Your Ref: SSD 7919

Council Ref: DA371/17
(KRR) (CIS)

23 November 2017

RE: Redevelopment of Loreto School (Masterplan, Stage 1 and concept Stage 2 and 3)

title
**Envelopes
Site Plan - Proposed Envelopes Final
Phase**

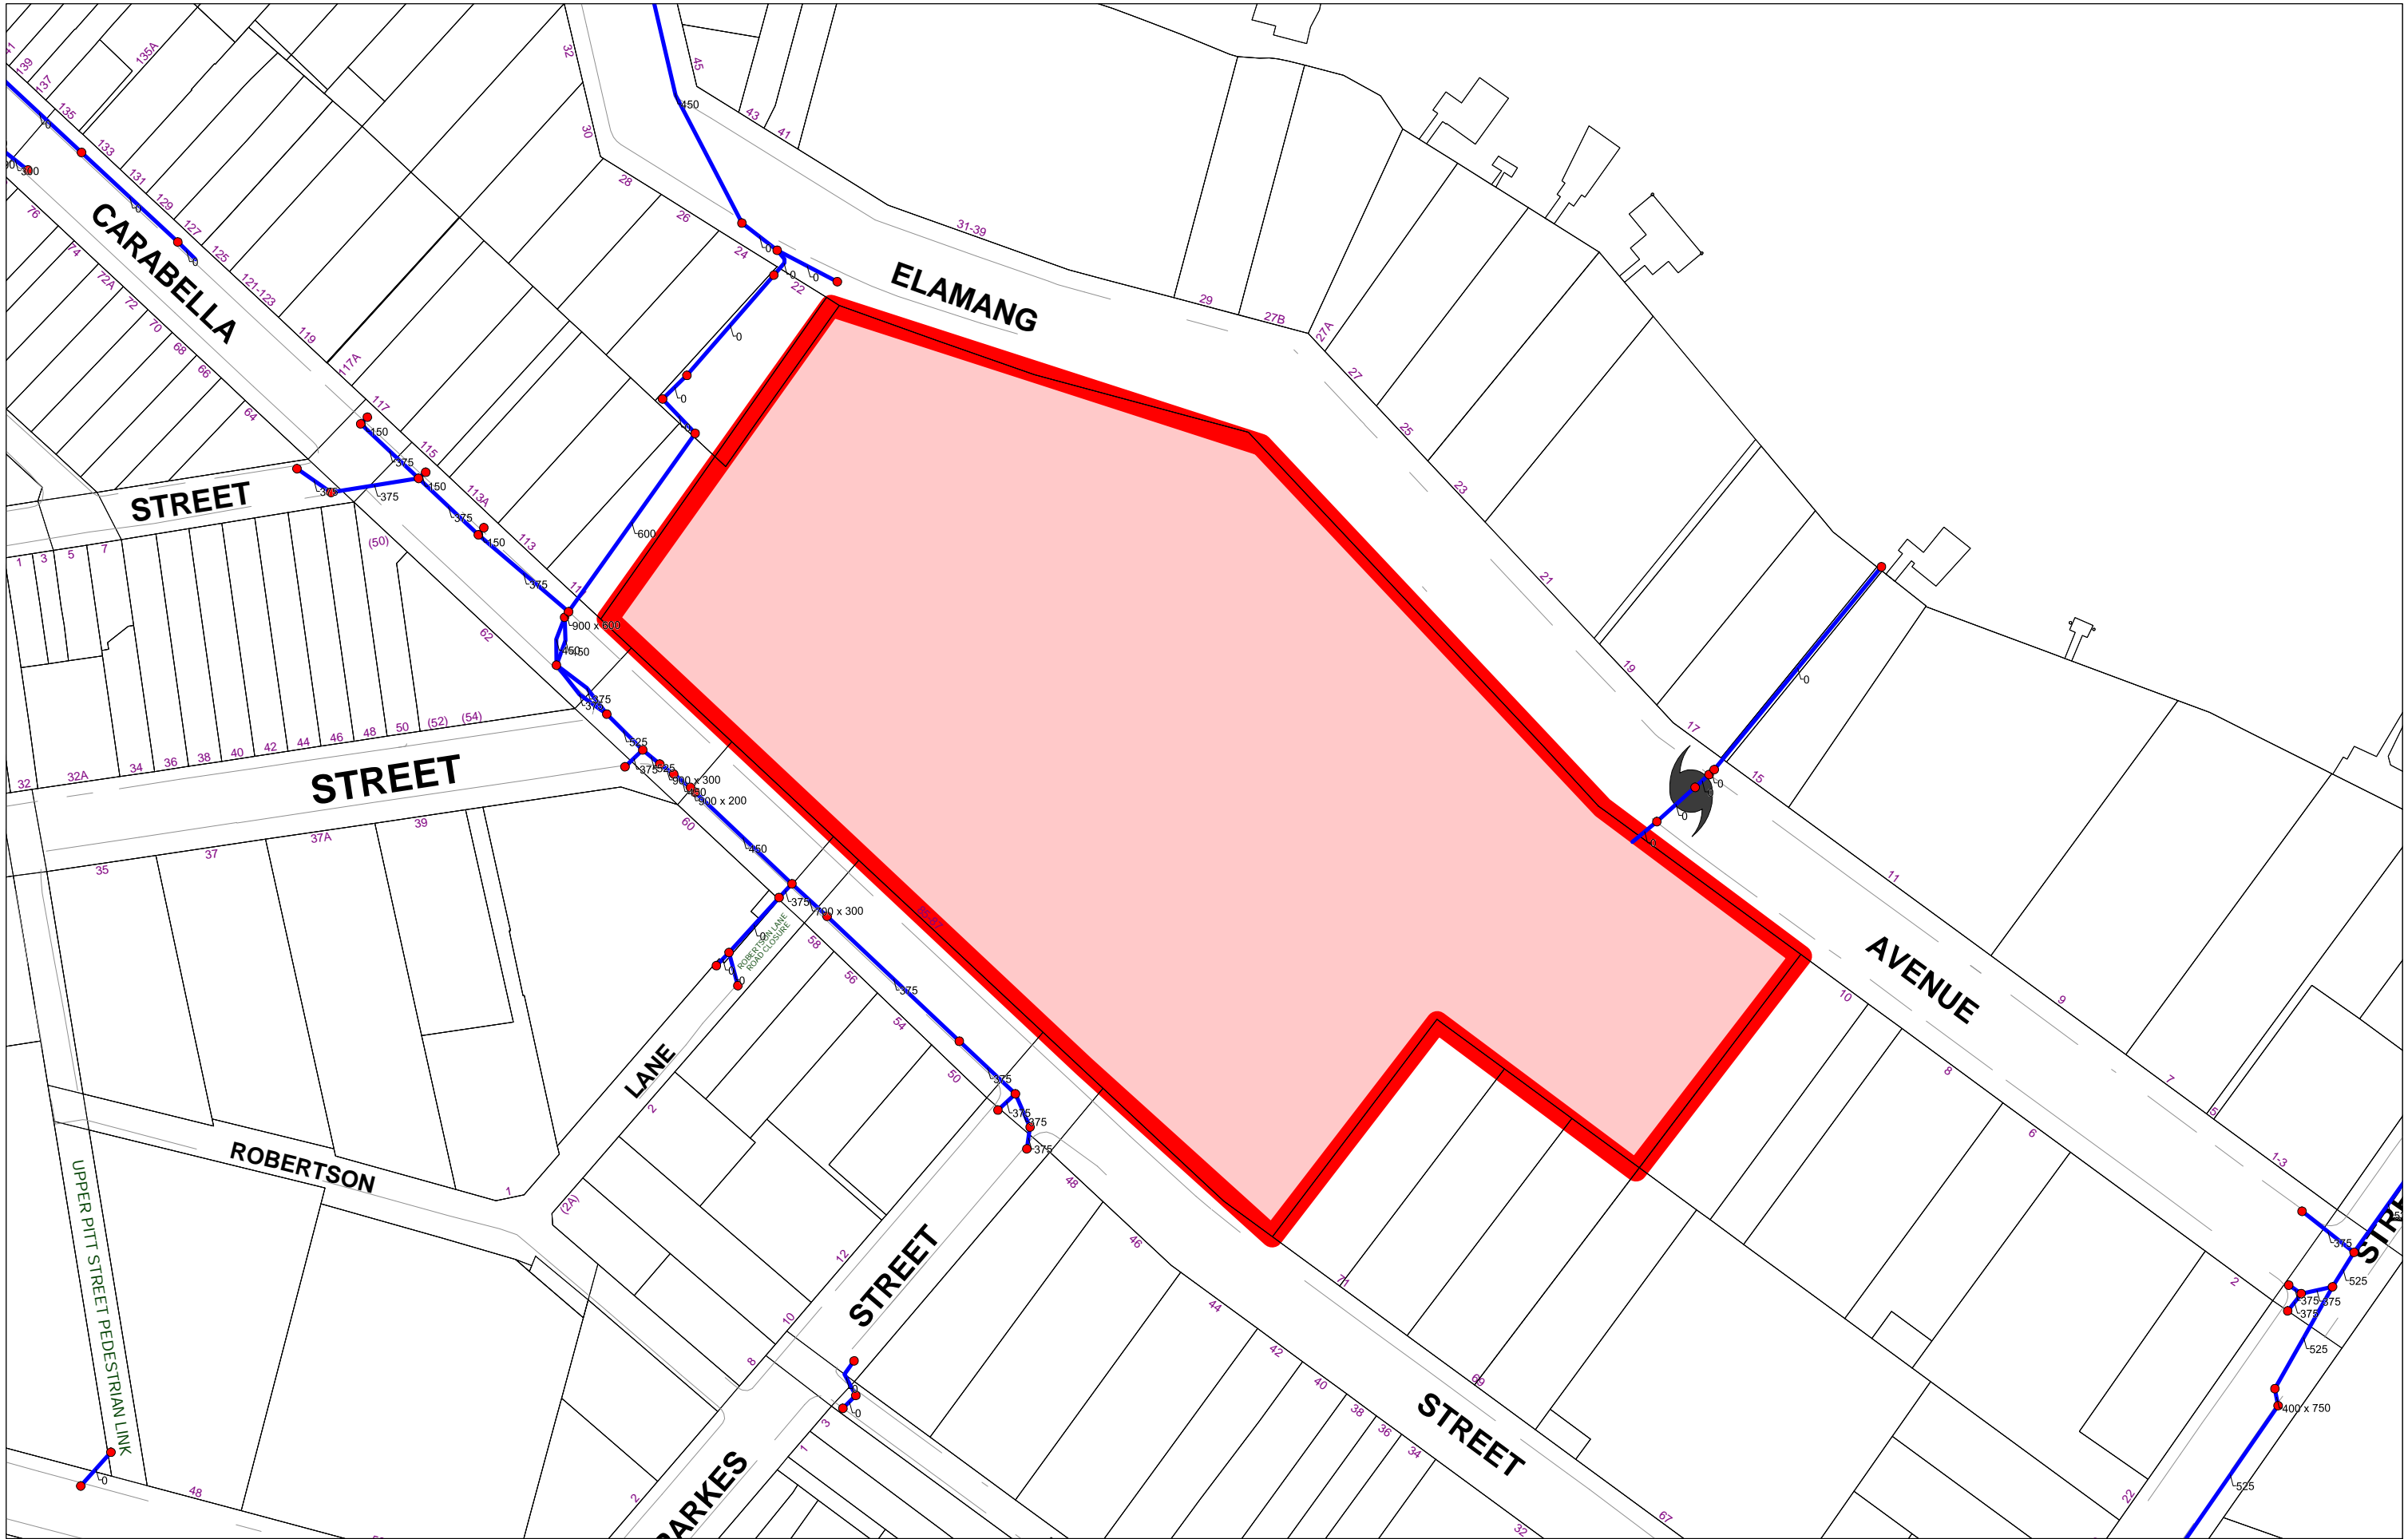
Clause 4.3(3) of NSLEP 2013 states that the maximum permitted building height on the site is 12 meters over the portion of the site which is zoned R4 High Density Residential. The works of most significance in the Stage 1 Western Precinct include the 7 story learning hub and an overall height of 14.5 metres exceeding the height limits for this zoning (12 metres).

North Sydney Council is of the view that the scale of the New Buildings particularly the new additions to the western building (Learning hub) located close to the adjoining boundary site are incompatible with the sites adjoining and opposite along Carabella Street and Elamang Avenue. Existing buildings at the eastern end of the sites are zoned R2 Low Density Residential with a maximum permissible building heights of 8.5 m (**refer to Figures 1 and 2 below**).

The height and depth of the building is such that the new Learning hub building will significantly impact upon the eastern outlook currently afforded from 111 Carabella Street residential dwellings.

The new works to the new Learning hub in Stage 1 of the proposal propose a new rooftop recreation area can introduce amenity impacts such as overlooking and privacy impacts. The height, depth and proximity of the new Learning hub to the Marian Centre will also significantly reduce solar amenity to the Marian Centre and adjoining residential properties to the west.

The proposed extended Learning Hub (Stage 1) has between a minimal side setback to the western boundary of the site which is considered insufficient for a building of this scale and does not provide for adequate building separation with the existing townhouse development at No's 22 Elamang Avenue and 111 Carabella Street.

A greater building setback to this western boundary should be provided with additional deep soil landscaping and minimize the visual (bulk and scale) and privacy impact of the new learning hub building to this adjoining property.

Privacy concerns are raised regarding the lower levels of the new Learning Hub at the western end of the site and the view and noise corridor created as a result of the orientation of and depth below ground level of the lower levels of the hub towards the existing residential flat building at 22 Elamang Avenue, Kirribilli.

Additionally, the new Learning Hub building proposes a new rooftop activity area. Any use of this area should be restricted to ensure there are no adverse noise or visual privacy impacts occurring from this new roof area.
